Re: SEPA Comments for MI Treehouse (5637 East Mercer Way)

David L. Anderson PE
9200 SE 57th Street
Mercer Island, WA 98104

ROOF AREA	2150 SF
HOUSE FOOTPRINT	1631 SF
DRIVEWAY	1560 SF
SITE DISTURBANCE	6326 SF
WETLAND DISTURBANCE	3561 SF
STREAM BUFFER DISTURBANCE	5195 SF
BOTH STREAM & WETLAND DISTURBANCE	2294 SF

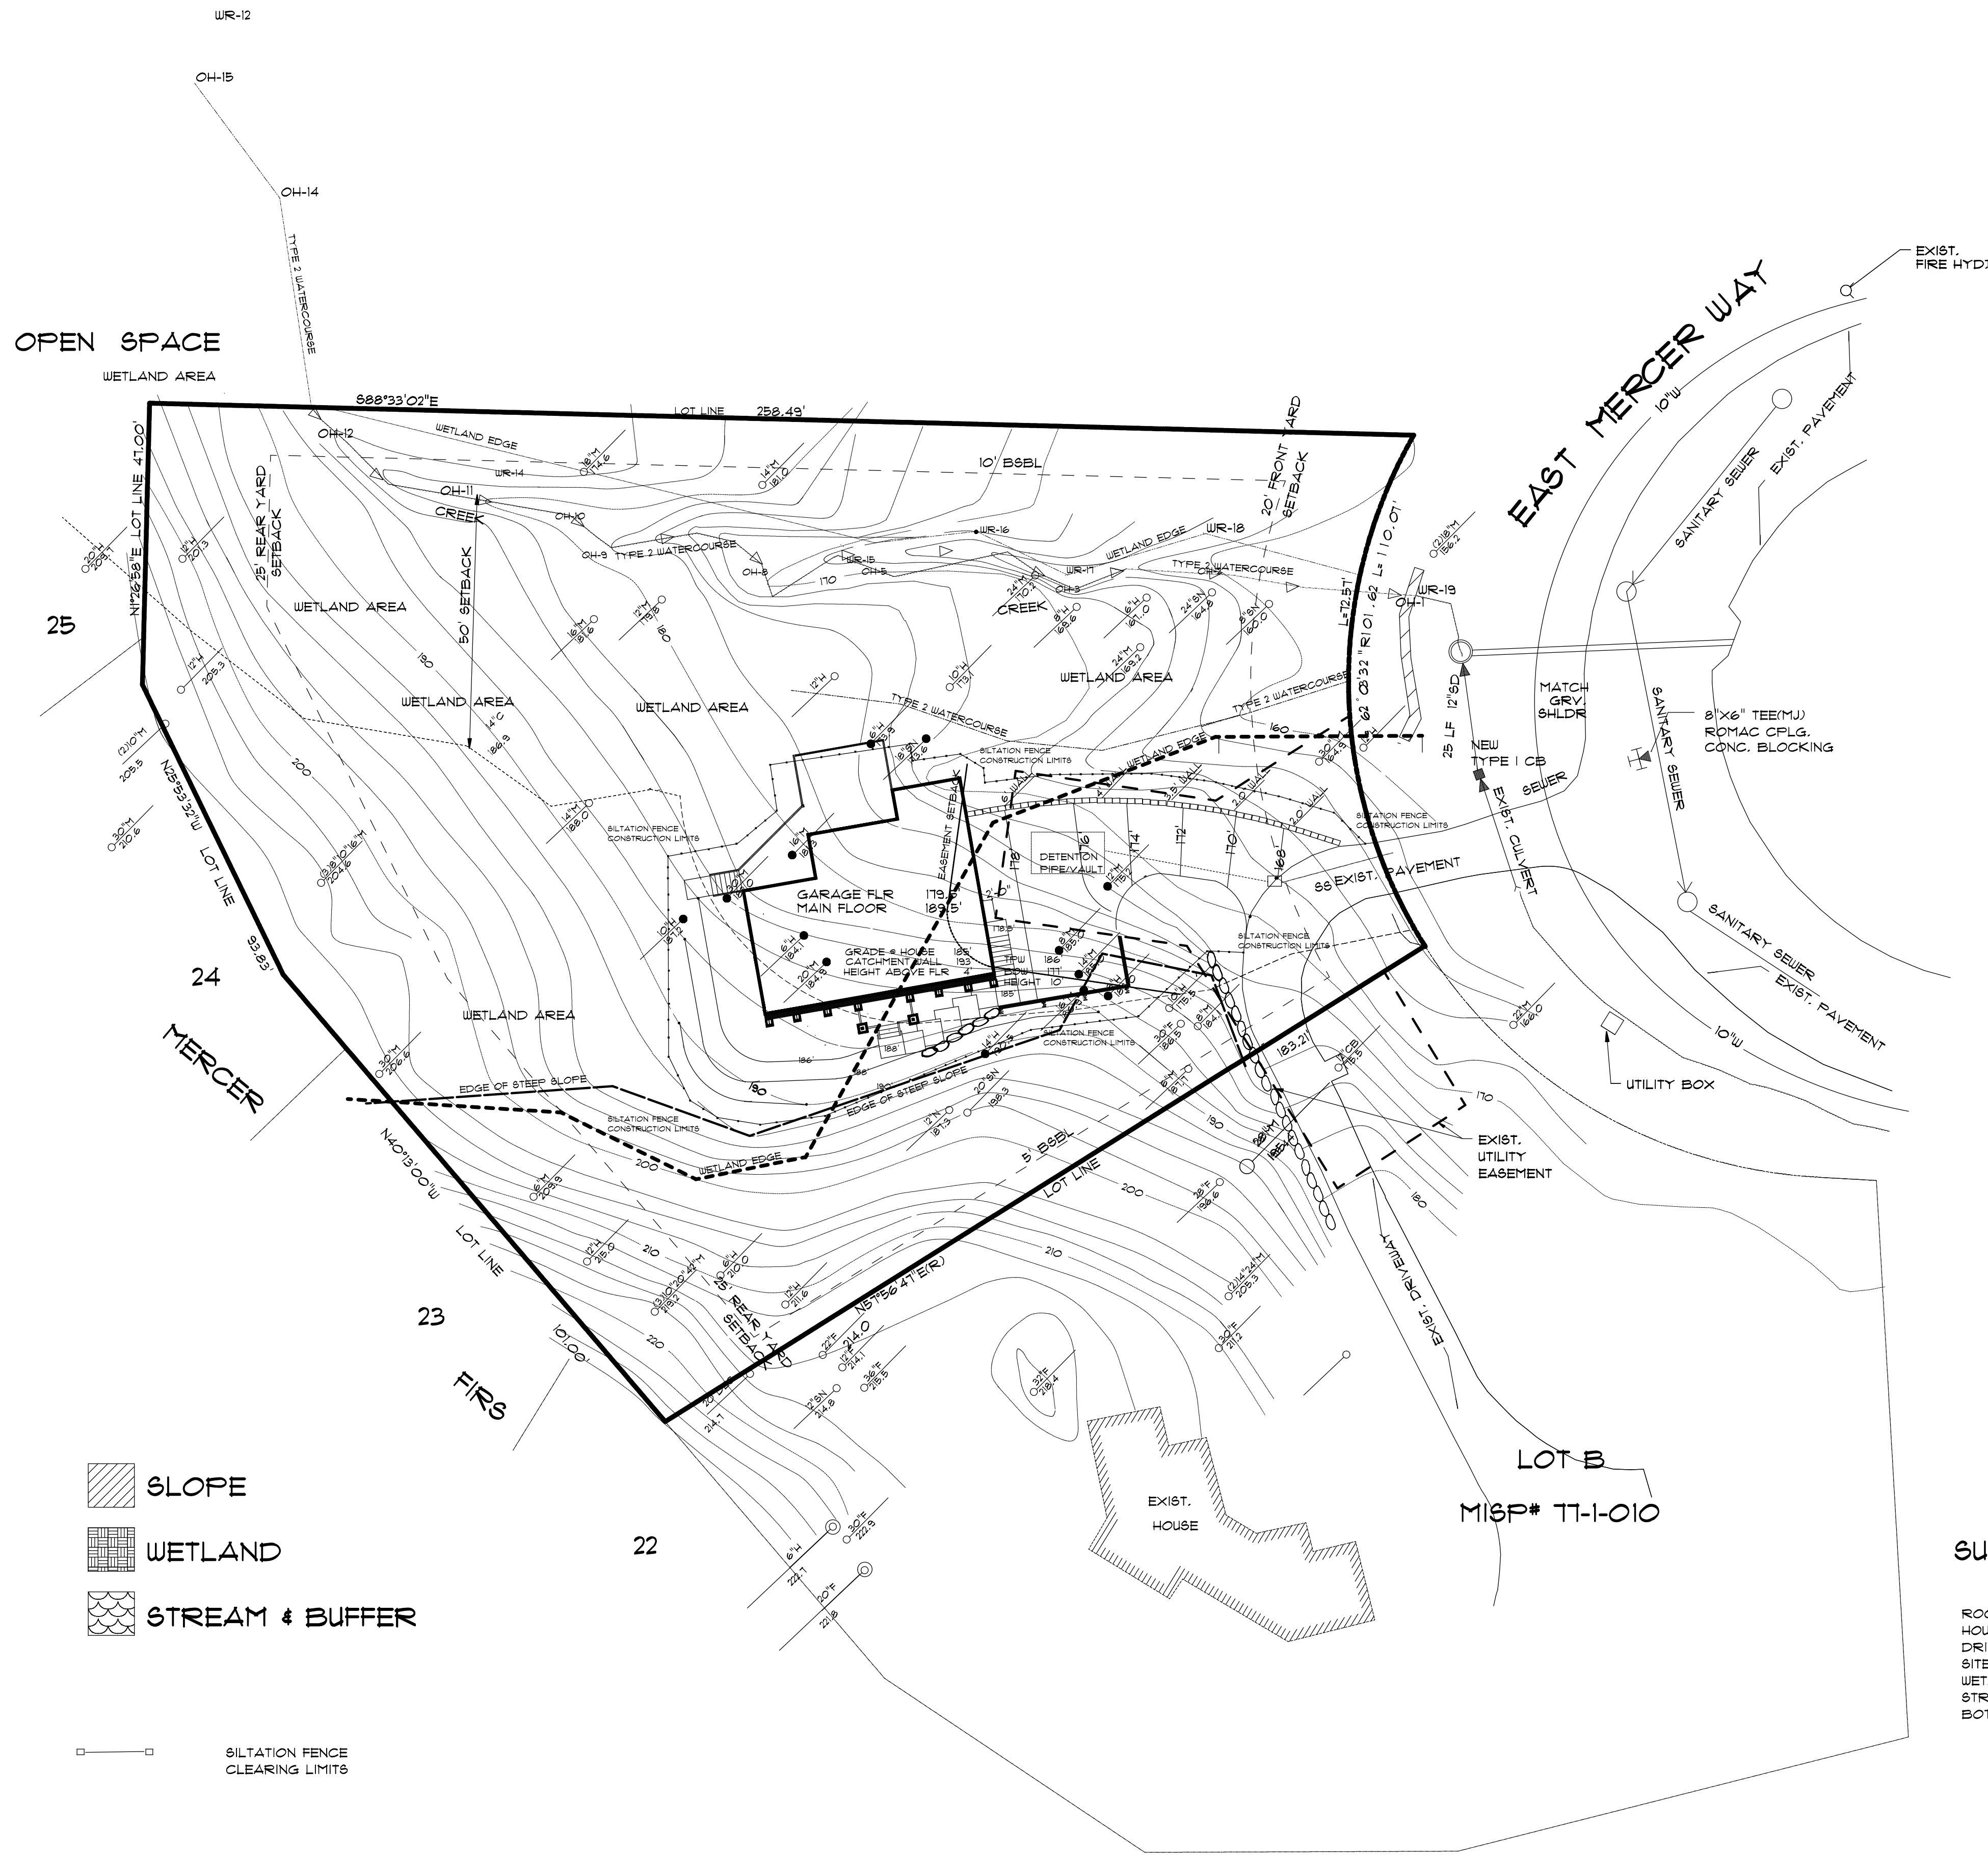
The checklist response only lists areas but does not include any grading quantities (cubic yards of cut and fill) as would typically be required to adequately address this question. With the installation of retaining wall that will be at least 10' in height and a storm water detention vault, these cut and fill quantities are significant and should be enumerated in the response to the question. Please note the area of disturbance listed in the SEPA checklist is not current with those listed on the current plan.

The checklist response only lists areas but does not include any grading quantities (cubic yards of cut and fill) as would typically be required to adequately address this question. The response to the question indicates no dredging is anticipated. The response should address the significant soil quantities that will be excavated and removed from the designated wetland areas. As noted above, the installation of retaining wall that will be at least 10' in height will be located within the existing wetland.

The response from the wetland consultant relative to ESA's comments and my previous e-mail includes the statement that water will be conveyed from the retaining wall drain to a spreader northwest of the building site that would recharge the existing wetlands. However, the elevation of the retaining wall drain will be below the existing surface grades in the wetlands to the northwest. This will not allow for positive drainage from a gravity system. The existing wetland elevation at the northwest corner of the proposed residence is 182. To achieve positive drainage from the wall to the northwest, the spreader trench would need to be very close to the water course to discharge at an elevation around 178. This would create additional temporary and permanent impacts to the existing wetlands beyond what are currently accounted for in the area summaries identified in the current reports and site plans. I appreciate the fact that detailed design documents are typically not part of a SEPA process. But short written responses do not accurately quantify the wetland, watercourse, and associated storm water impacts. Preliminary or design development level drainage plans that account for the site topography, the water table elevation, and required discharge elevations must be provided to accurately identify the wetland and watercourse buffer impacts.

The SEPA response also does not reference what certainly will be a permanent impact to the existing up-gradient wetland areas. As previously noted in earlier correspondence a perforated drain placed well below the surface will almost certainly be a permanent impact on the existing wetland areas south, west, and potentially northwest of the proposed building location. A portion of this area is indicated on the 2018 site plan as temporary wetland disturbance due to grading activities. The wall construction with drainage collection well below the wetland surface will permanently impact the wetland area and could de-water a significant portion of the upland wetlands including those that extend beyond the parcel limits.

The location of the stormwater detention storage tank could also impact the existing wetland area beyond what is shown in the revised 2018 plan. The tank identified in the preliminary calculations included a 17.45' by 17.45' footprint with a 5' depth. The tank would typically need at least 2' of cover from the lowest surface elevation to allow for installation of the driveway and to provide cover for the associated storm drainage conveyance piping that connects the development area to the detention storage. The tank installation would typically include granular bedding and backfill materials. As the excavation would boarder a wetland, the area would need to be de-watered to install the tank. The
